Tel: 01903 737756
Email: planning@arun.gov.uk
www.arun.gov.uk/planning
Please ask for: Ms Iqraa Malik
Email: iqraa.malik@terraquest.co.uk
Telephone: 0121 234 1390
Our Ref: AB/25/26/L
Your Ref:
Date: 17th April 2026

Listed Building Consent for Alterations, Extension or Demolition of a Listed Building

Development: Listed building consent to repair and strengthen existing roof structure and reinstate tiled roof.
Location: 19a High Street Arundel BN18 9AD

Drawing Title:
EXISTING AND PROPOSED ROOF PLAN
(NO CHANGES)

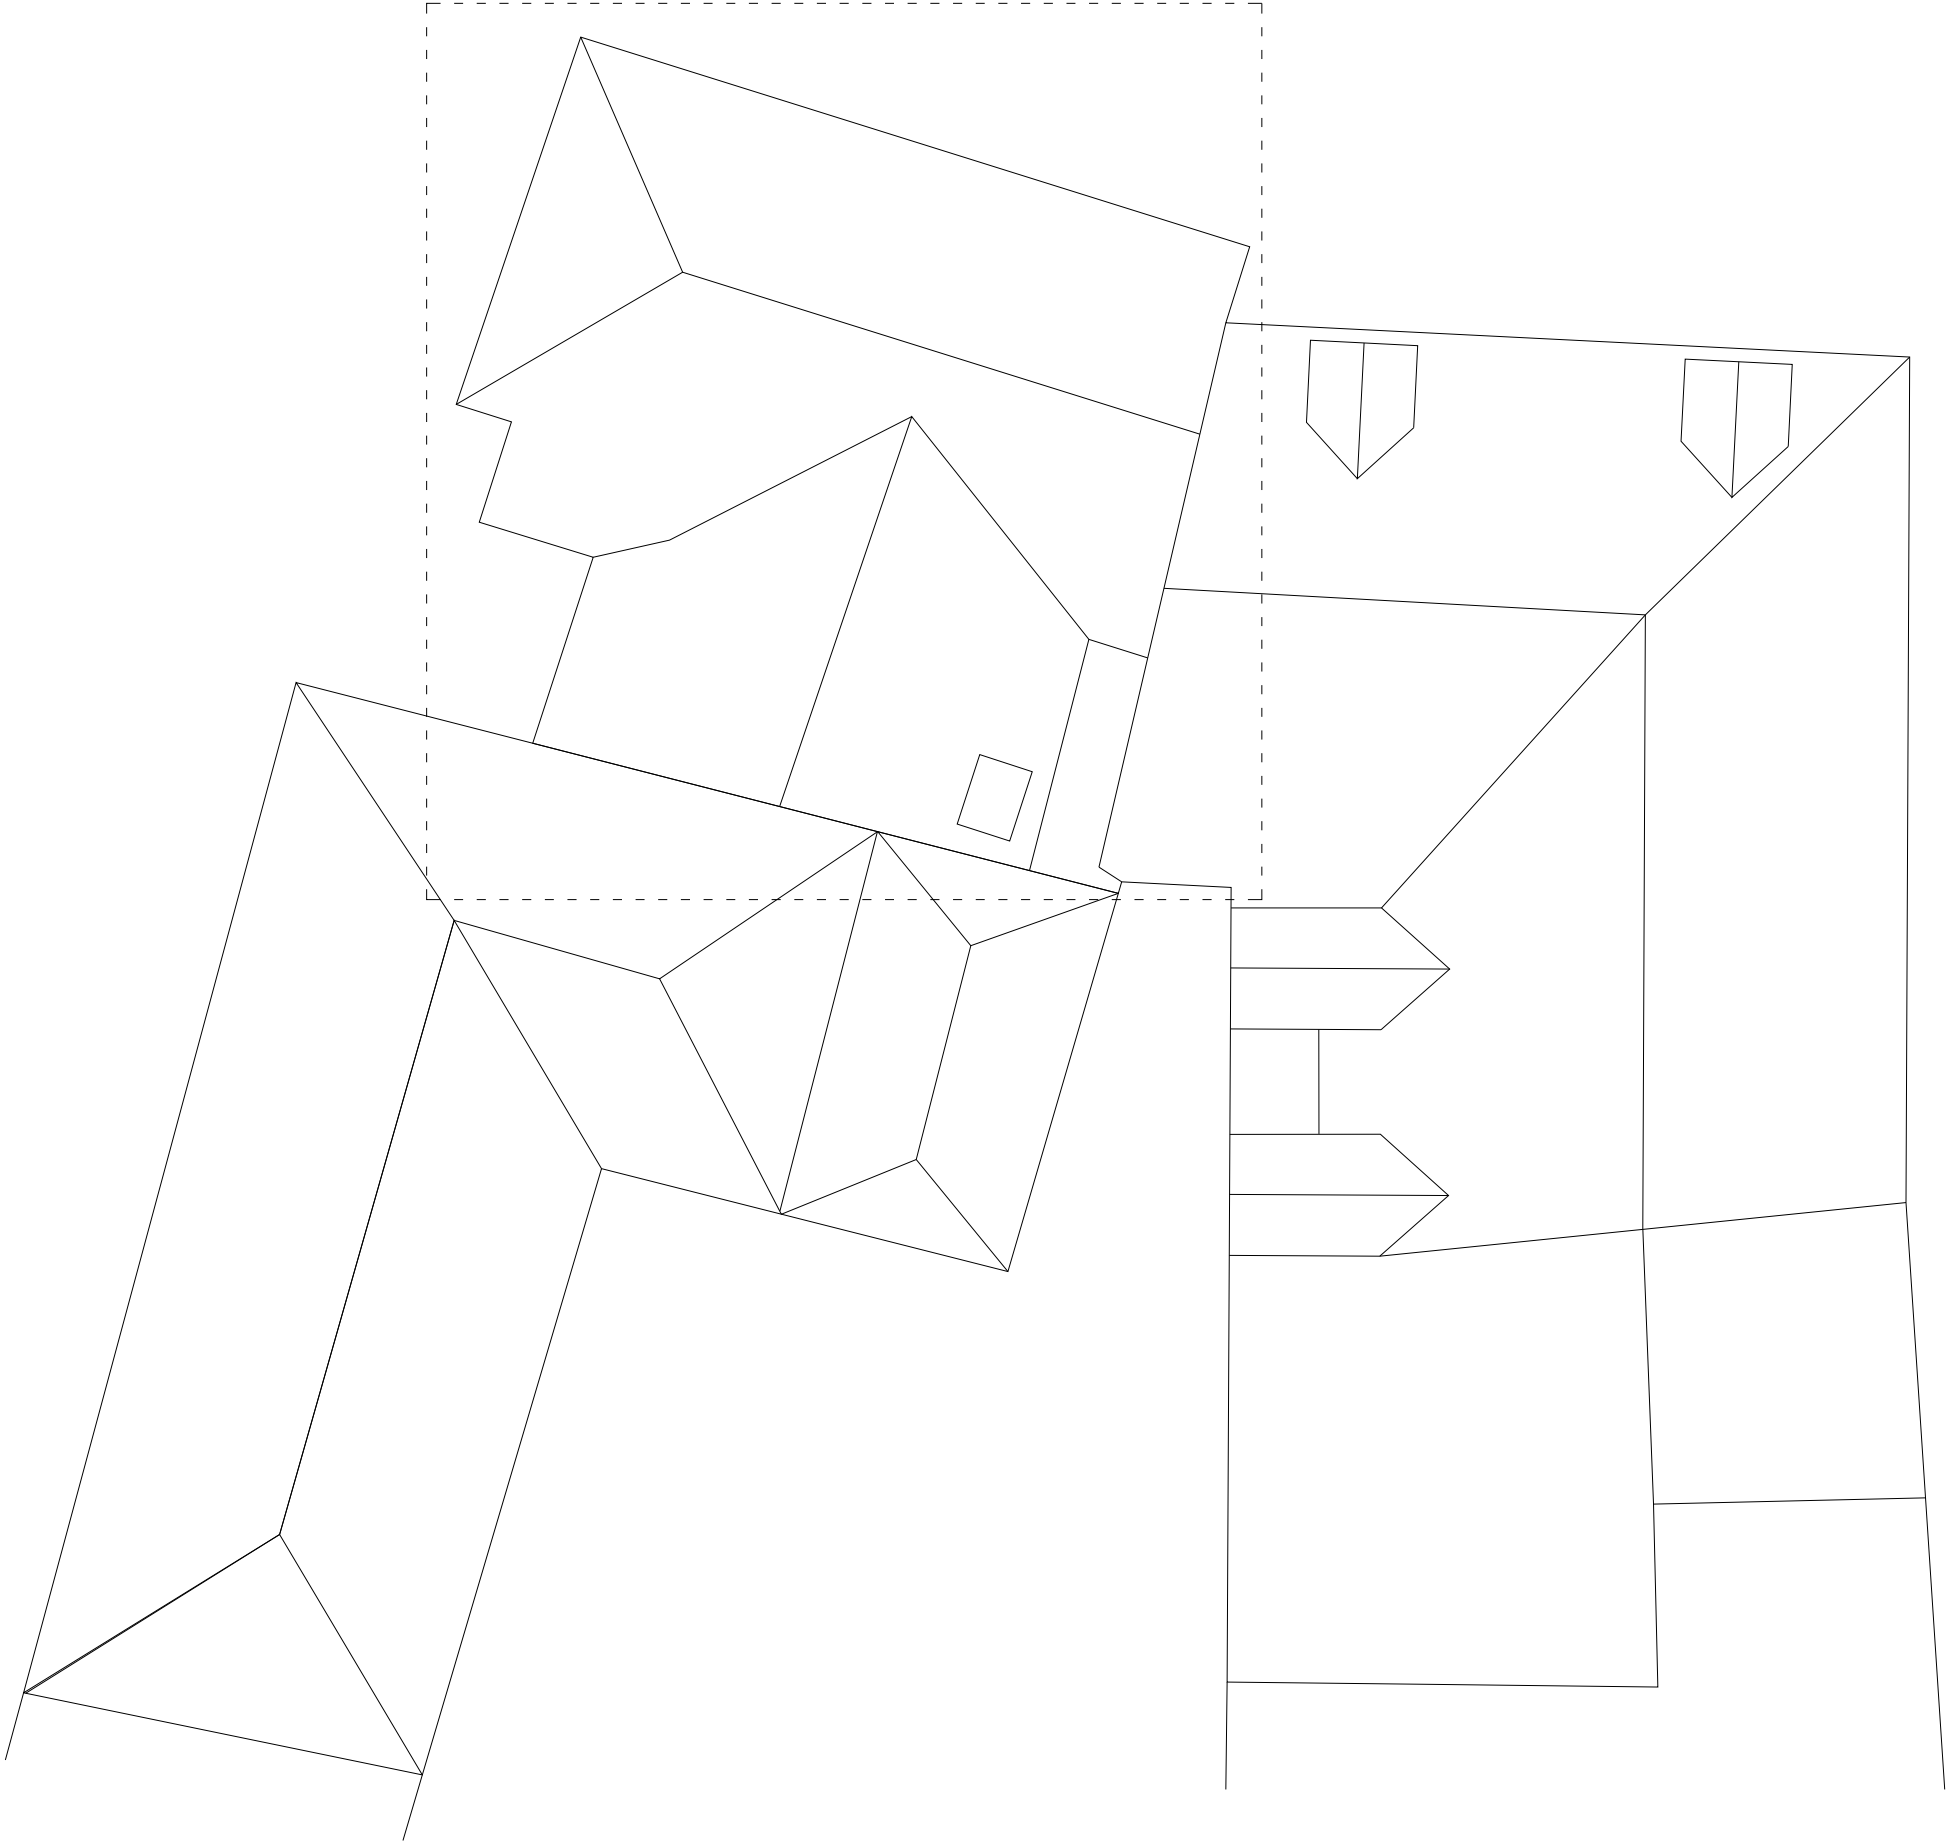
Please submit electronic plans showing the proposed roof plan. Alternatively, you can annotate the existing roof plan with the proposed works. Please refer to the Validation Requirements List for further details.
